**Application Reference:** 6/2020/3222/NMA

**Proposed development at:** Former Volkswagen Van Centre Comet Way Hatfield  
AL10 9TF

**Proposal:** Non-Material Amendment following planning permission for *“Demolition of existing buildings and construction of new building comprising 118 residential apartments, layout of parking areas, landscaping, electricity substation and ancillary development”* (6/2020/3222/MAJ)

While some proposed changes would be non-material, others represent material changes to the planning permission. Consequently, this application for a NMA is **refused**.

Project Name & Address
VOLKSWAGEN HATFIELD
 COMET WAY, HATFIELD, AL10 9TF
 Building Type
 RESIDENTIAL DEVELOPMENT
 Drawing Title
 AMENDED FLOOR PLANS- GROUND FLOOR

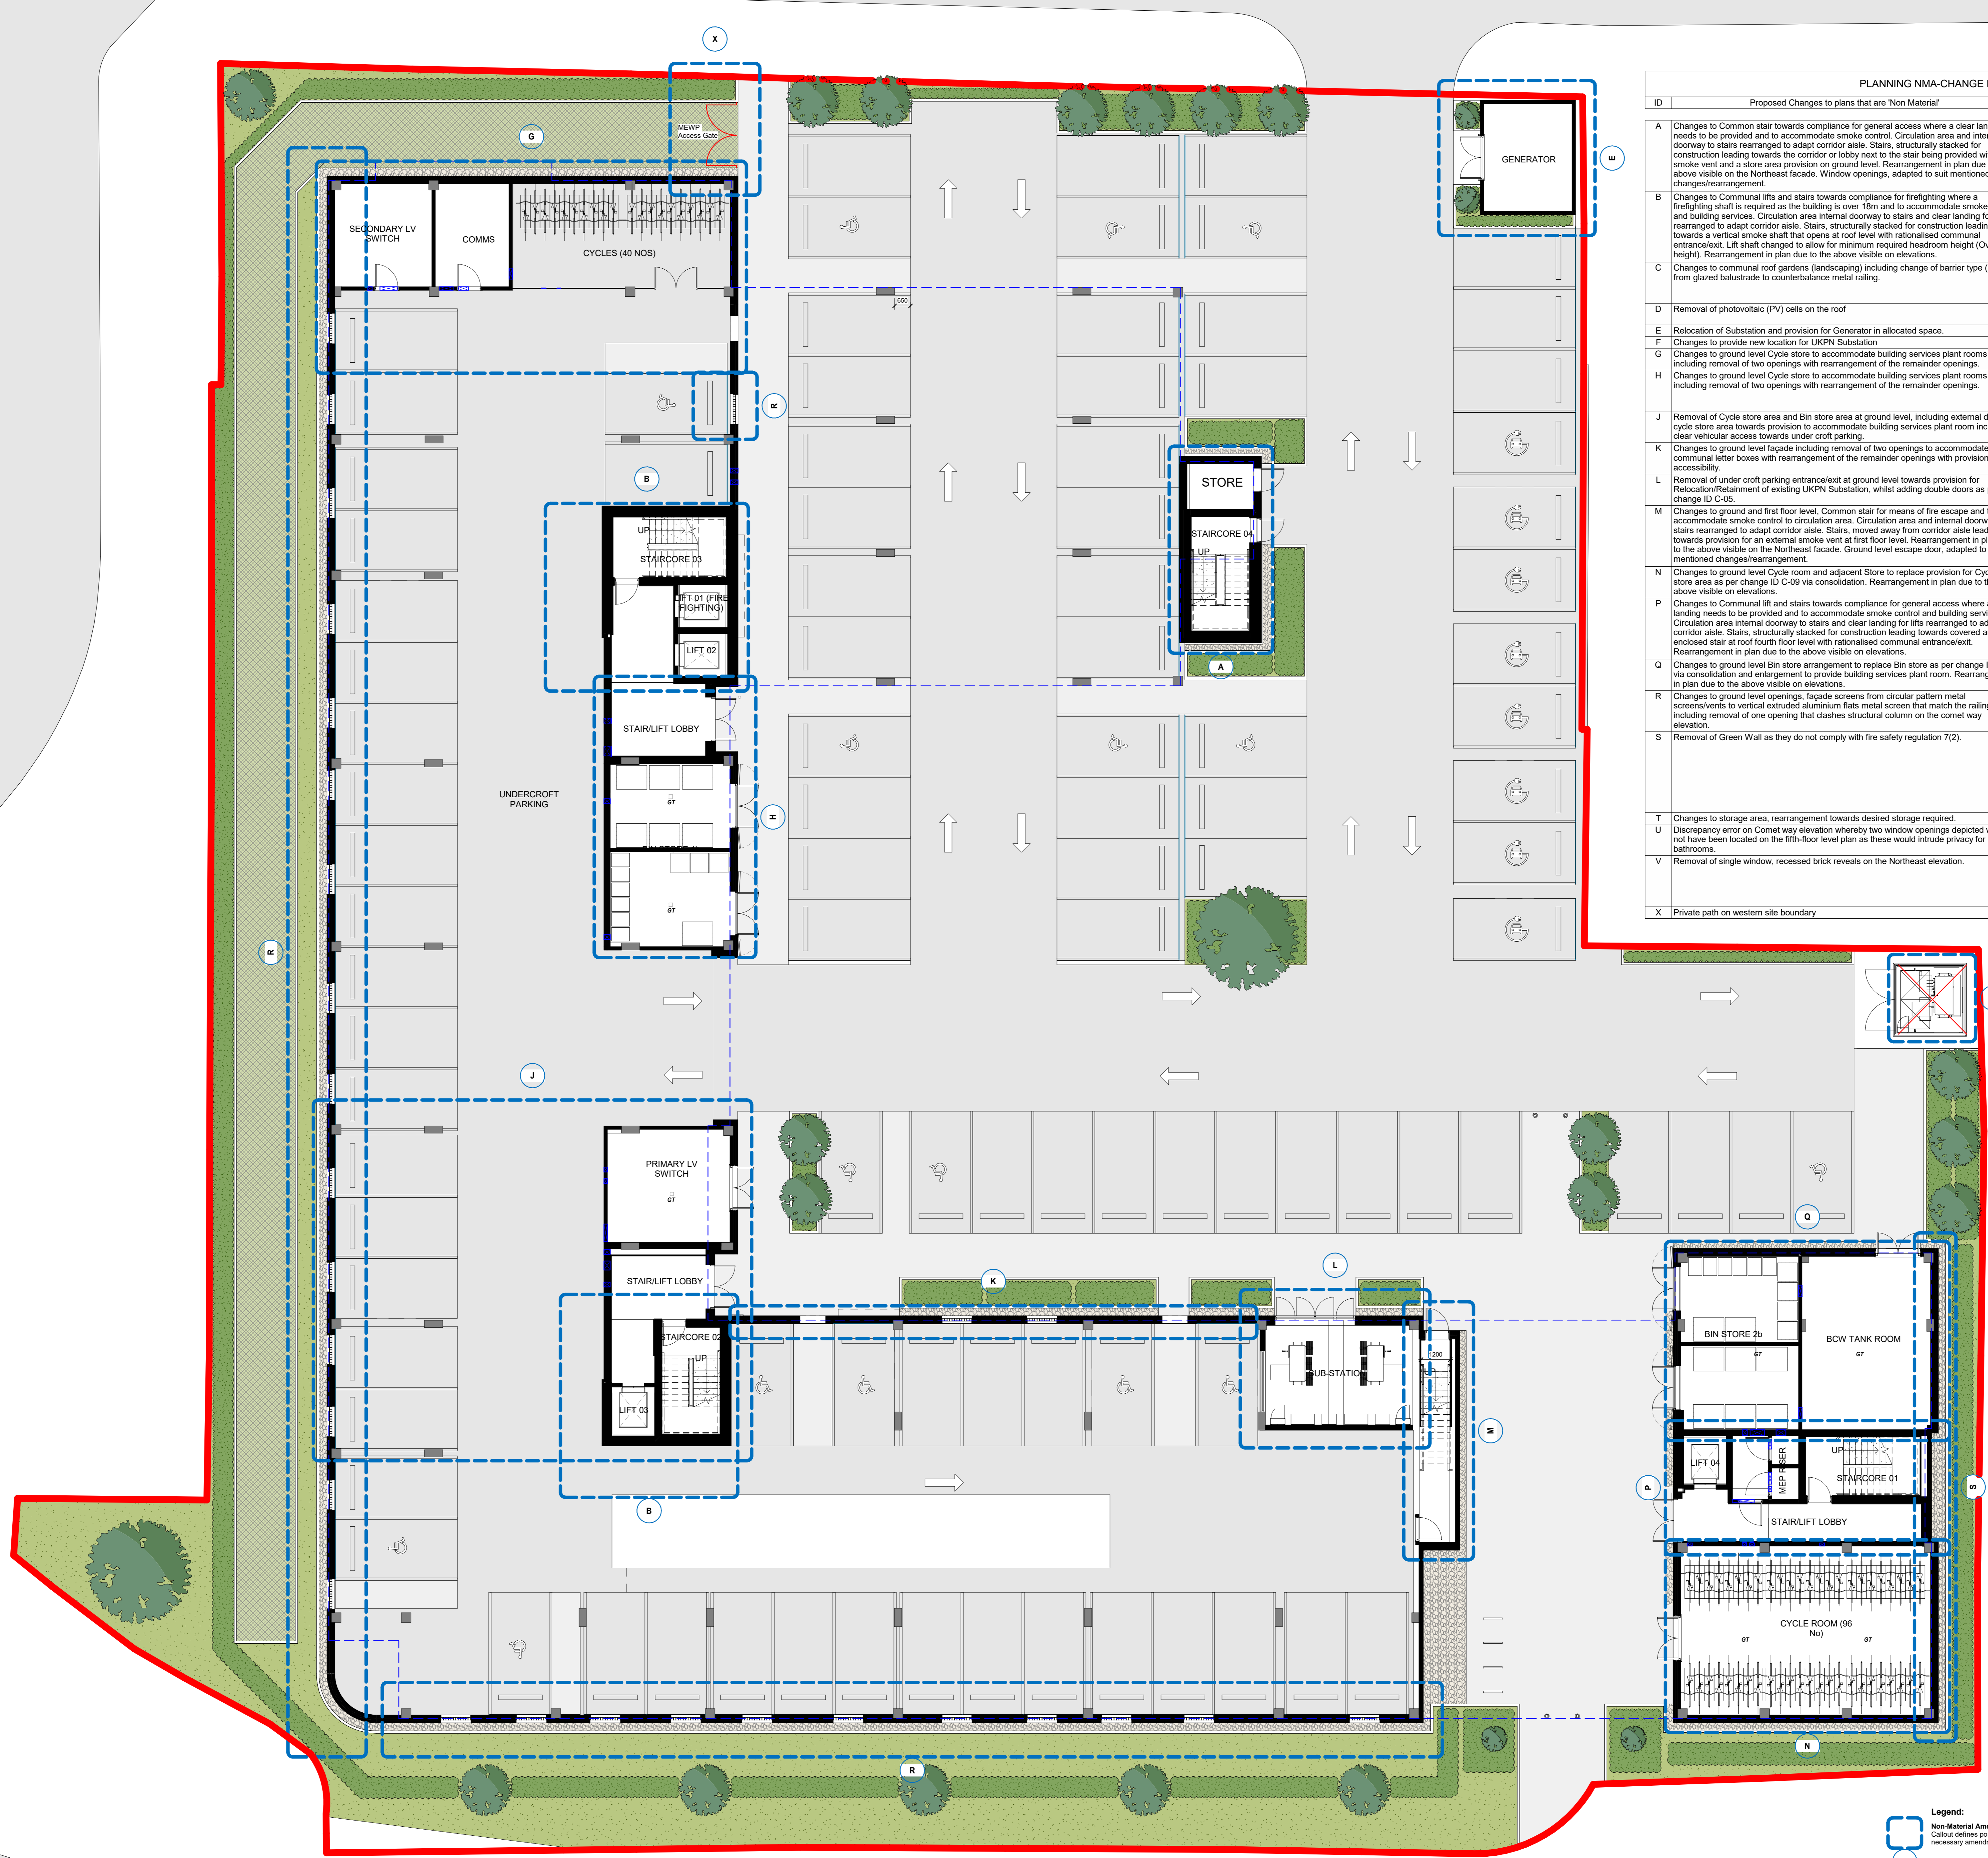
While the change to the bin store internal arrangements for secure access is, in itself, not material, it is noted that the overall number of bin stores to serve the whole development are proposed to be reduced from three to two and the cumulative size of the bin stores would be reduced. It is considered that this would be an

unacceptable change as the two proposed bin stores would not be able to collectively accommodate the number of receptacles required for this development. This change is therefore material.

See comments under 'Change H' regarding reduction in number of bin stores. This change is therefore material.

The removal of the under-croft parking entrance/exit in this location is a material change by virtue of the unacceptability of the proposed new single point of entry/exit. See section below titled 'Amended under-croft parking layout'.

See comments under 'Change H' and 'Change J' regarding reduction in number of bin stores. This change is therefore material.

It is noted that the parking layout for the scheme is proposed to be amended. As a fire appliance vehicle cannot access the under-croft area due to its height, a fire appliance hose connection will be required to access parking space 32. It is unknown whether there are any fire inlets or connections nearby or whether this is feasible. As such, there is a risk that this proposed change to the parking layout may not allow for access by an emergency fire appliance vehicle. This change is material as there is potential conflict with planning policy.

Project Name & Address
VOLKSWAGEN HATFIELD
COMET WAY, HATFIELD, AL10 9TF
Building Type
RESIDENTIAL DEVELOPMENT
Drawing Title
AMENDED FLOOR PLANS- FOURTH FLOOR

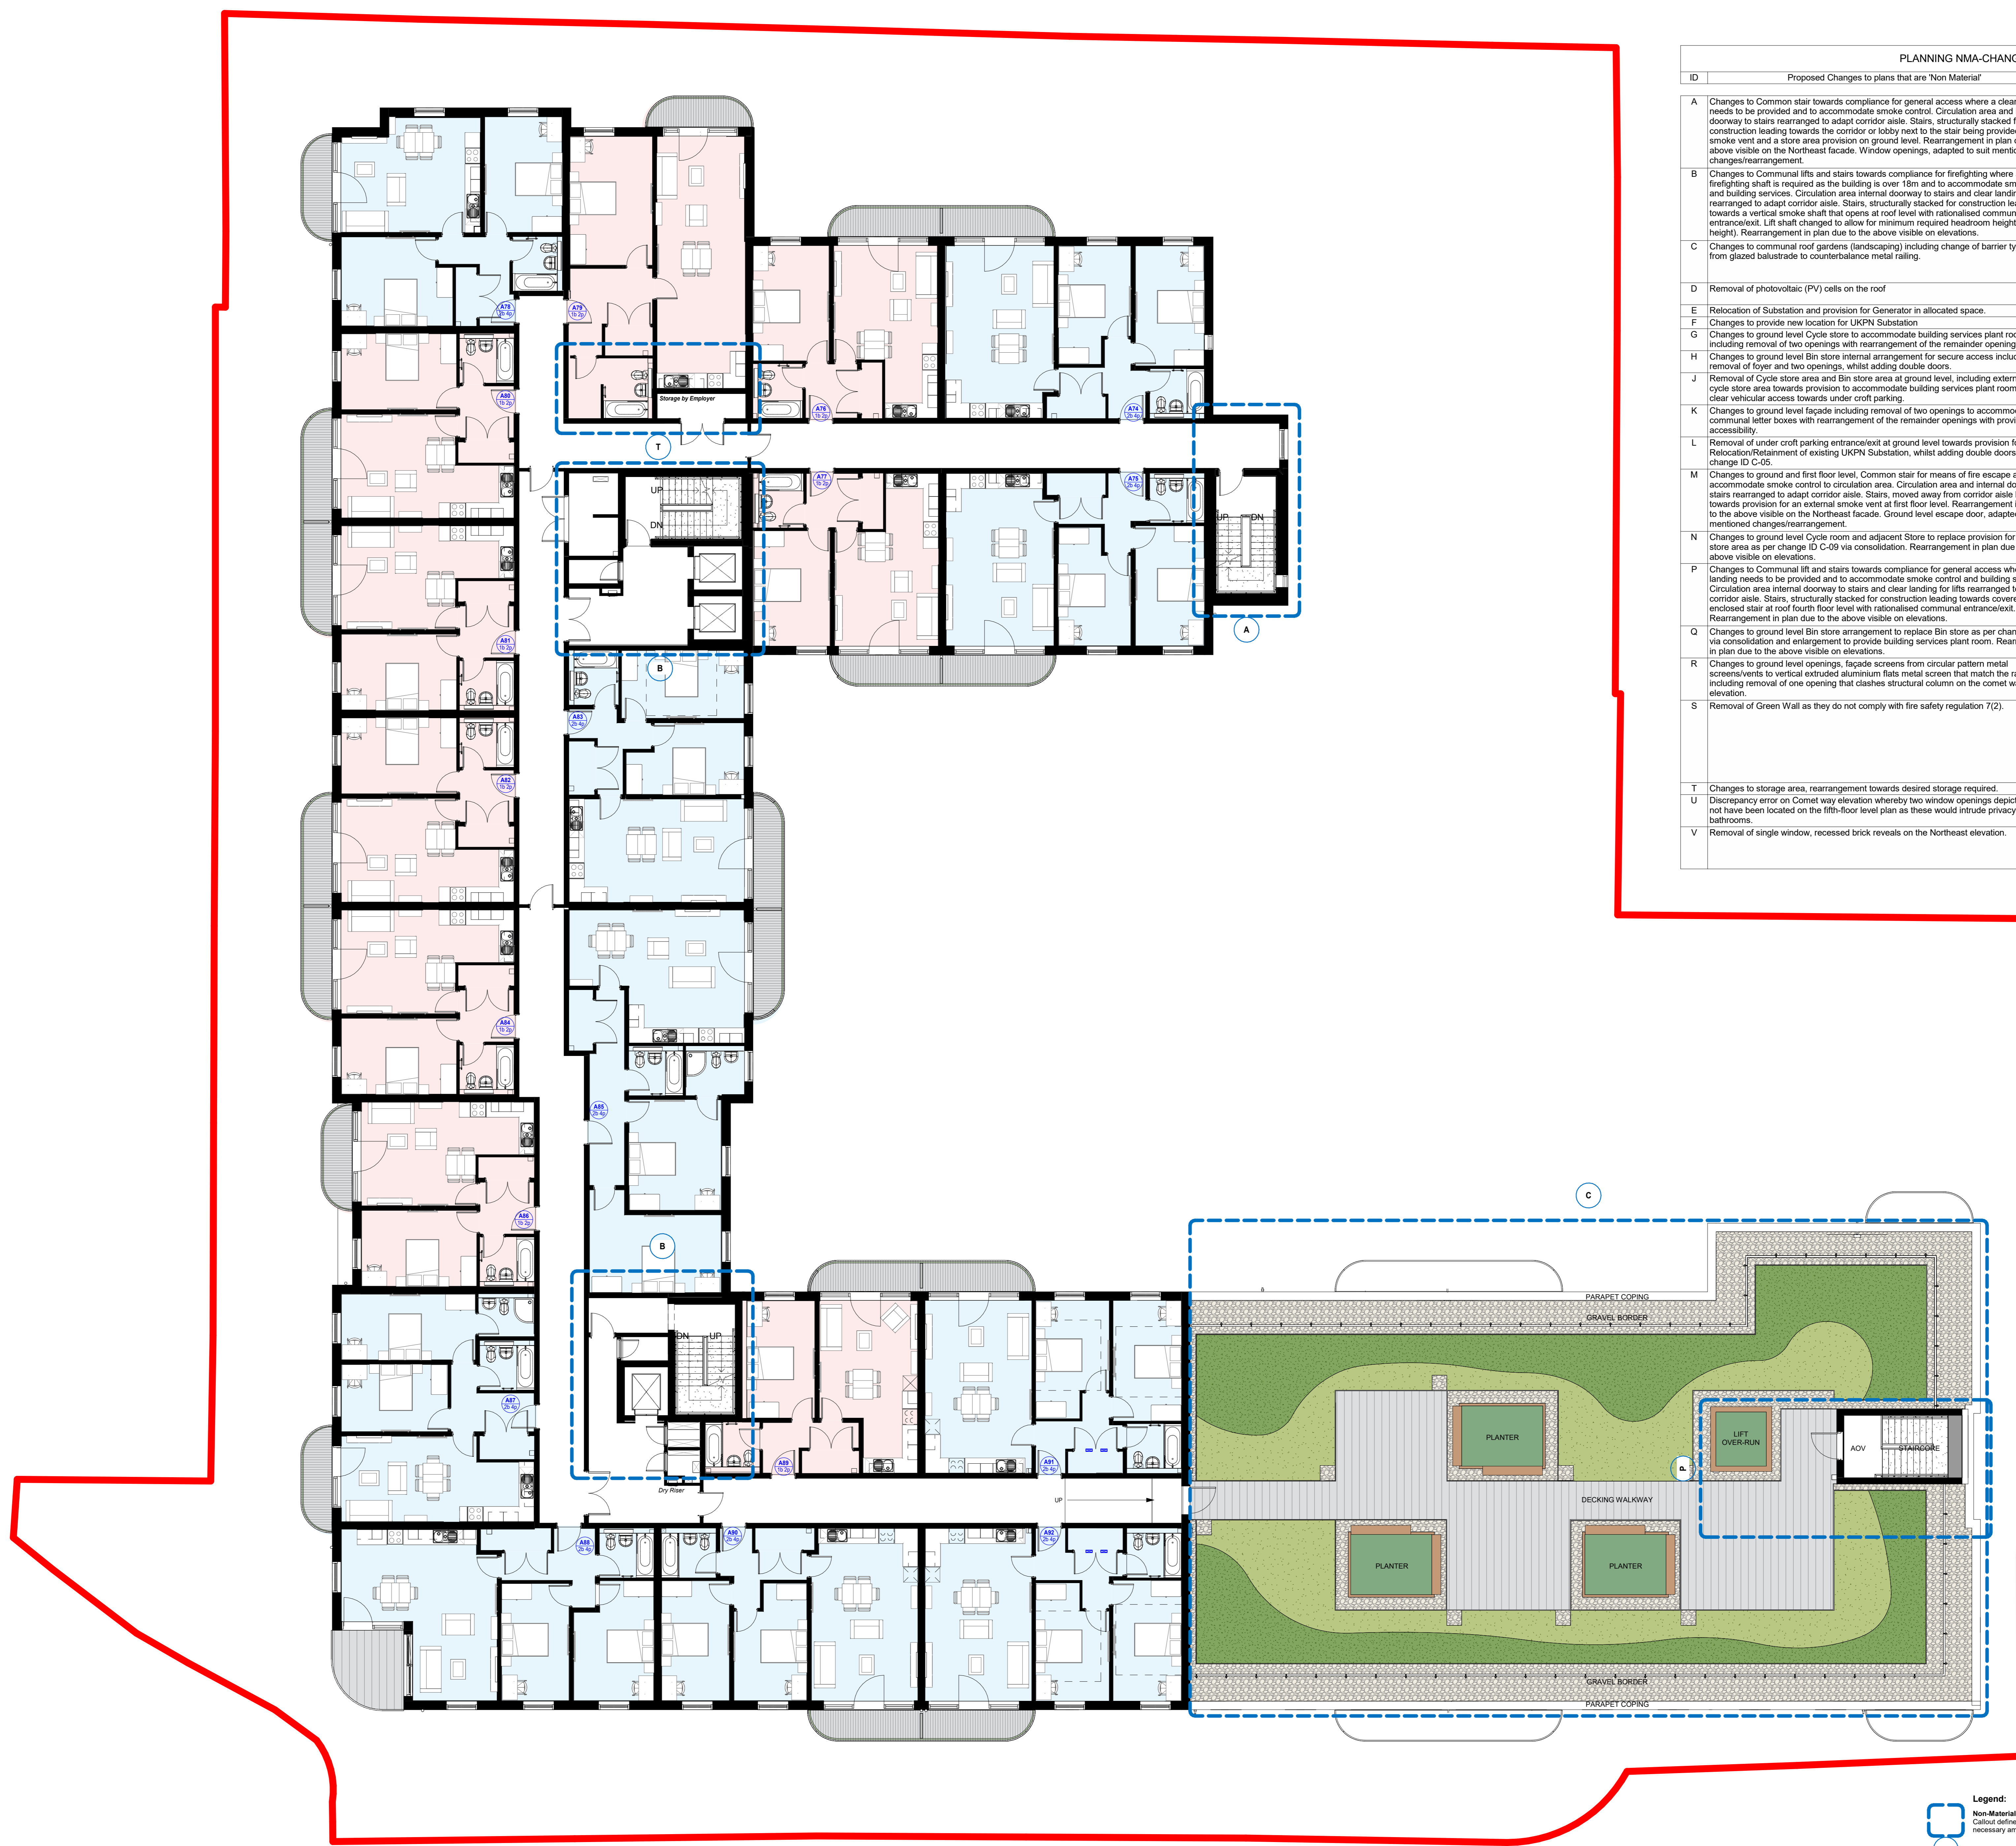
The Amended Fourth Floor Landscape Plan (drawing no: HAT-RDB-XX-04-DR-A-LND-0204) and Amended Fifth Floor Landscape Plan (drawing no: HAT-RDB-XX-05-DR-A-LND-0205) are acceptable and considered to be non-material.
